City of Albuquerque

August 8, 1977

Re: INDUSTRIAL ELECTRIC EQUIPMENT SERVICE IN ALBUQUERQUE, NEW MEXICO.

On the basis of the grading and the drainage plan submitted to this office, I find that I cannot agree with the results of the drainage report. My findings are as follows:

INDUSTRIAL ELECTRICAL EQUIPT.				SHEET OF
GRADING AND DRAINAGE PLAN				
ASSBURY & ASSOCIATES CONSULTING ENGINEERS ALBUQUERQUE, NEW MEXICO				
OWNER'S FILE NO. 77-117	DRAWN: D.P. TRACED: D.P.	CHECKED: J.T.A. APPROVED: J.T.A.	DATE: 7/77 SCALE: 1" = 20'

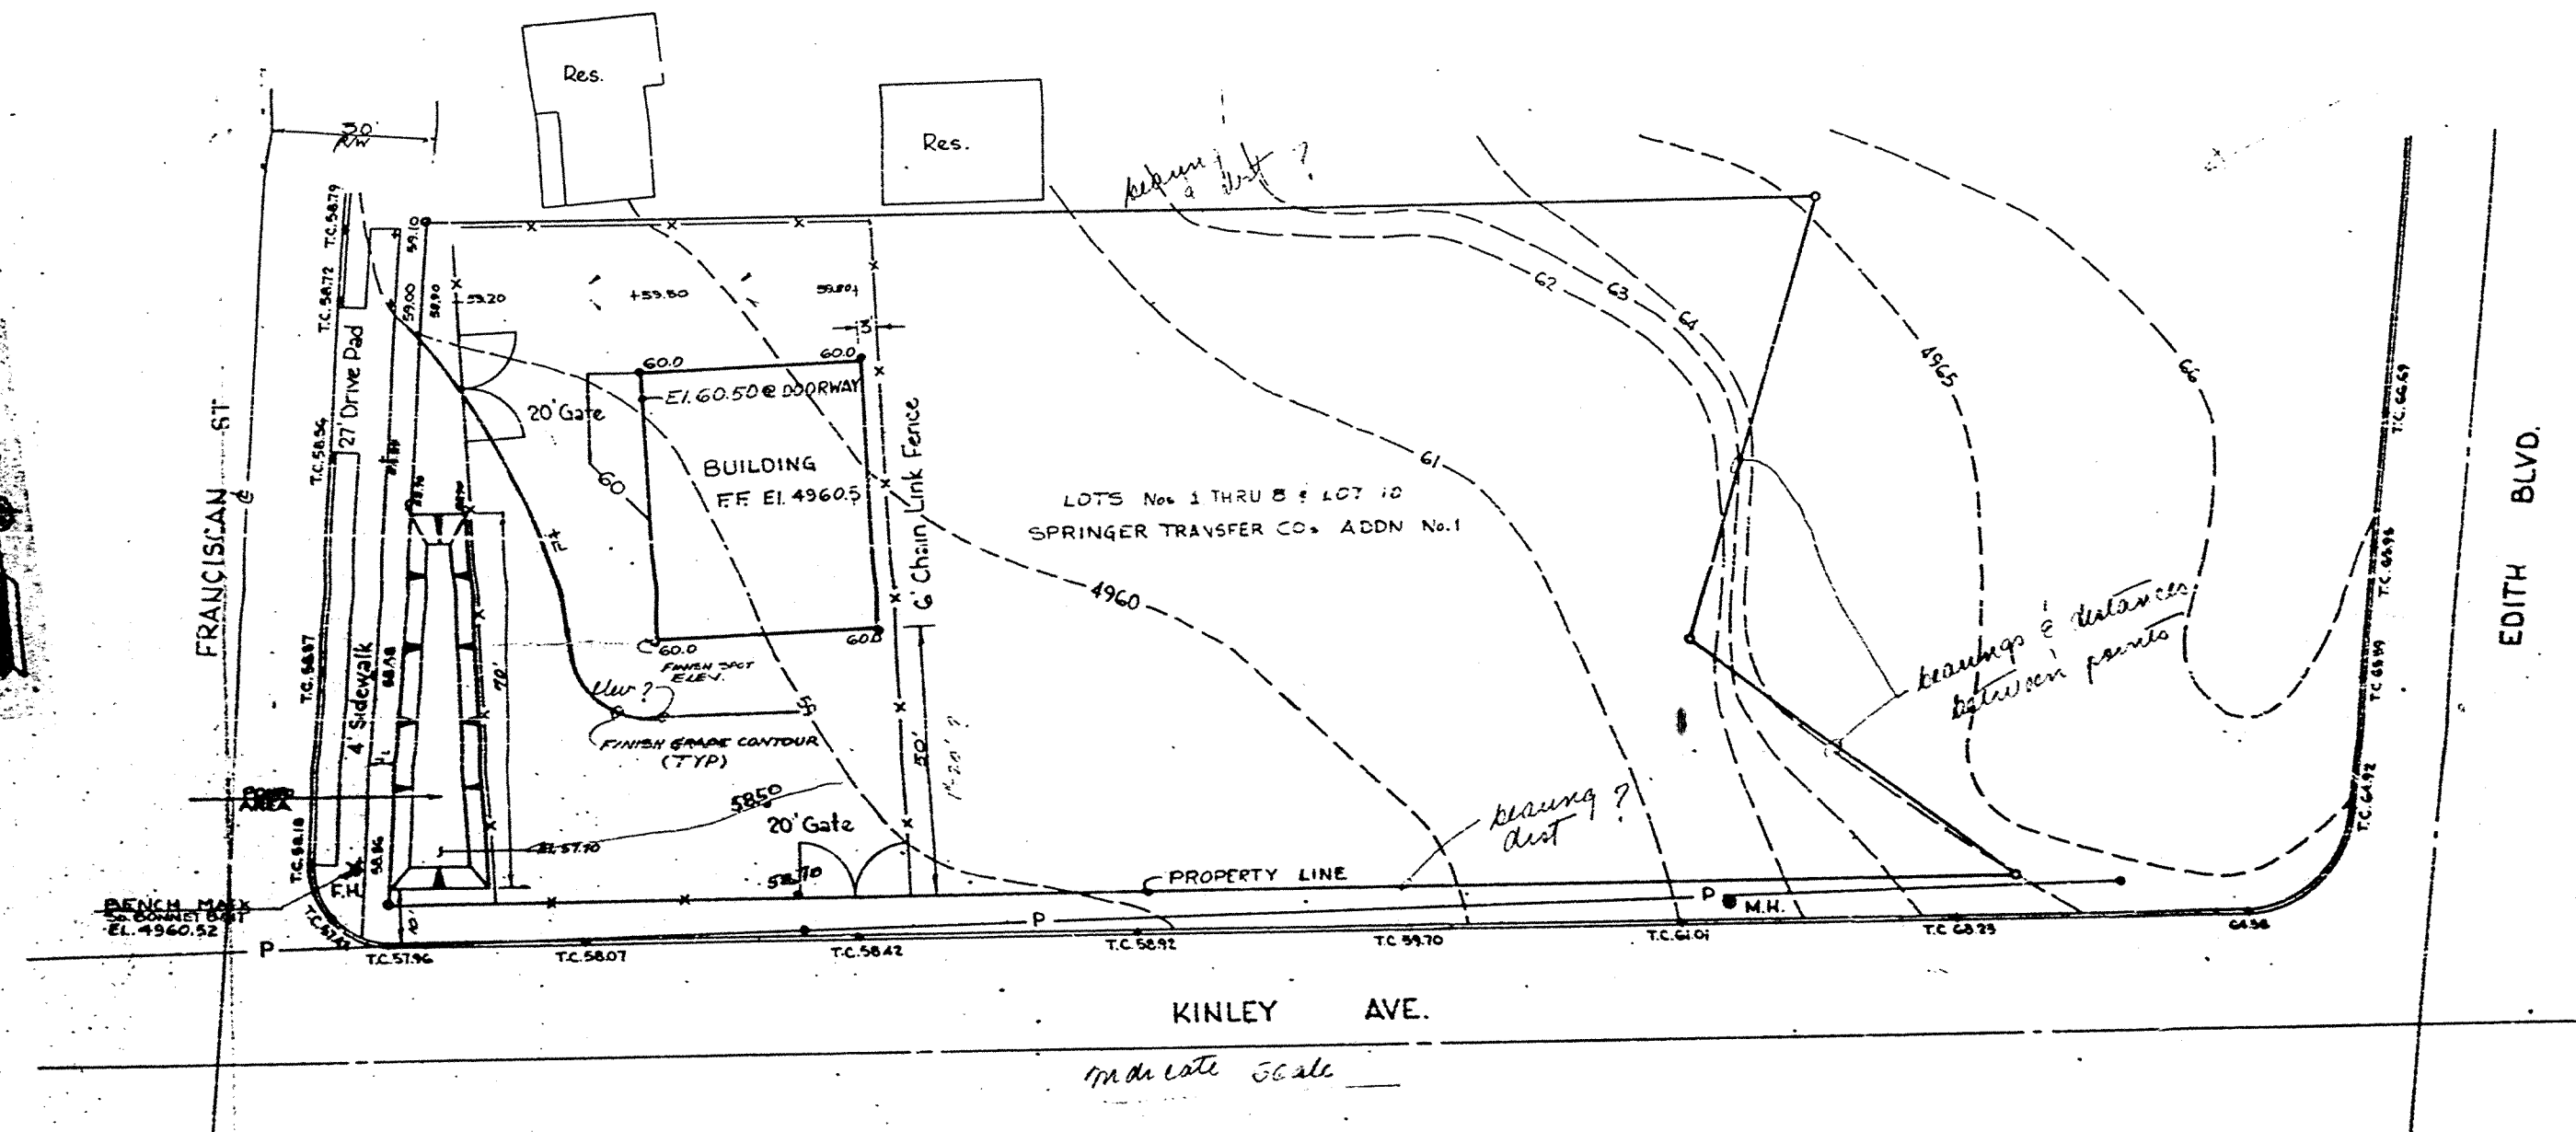
2. I notice that the ponding area provided appears located in part outside the property line (within Franciscan Street right-of-way?). If so, the pond would not be acceptable: ponding requirement must be located within the property without encroachment of public right-of-way (which is requested and dedicated for other public purposes).
3. The grading on the site as indicated does not insure the routing of the runoff through the pond. A good portion of the runoff can drain into the streets.

Please revise the drainage plan for the site to conform to the requirements above.
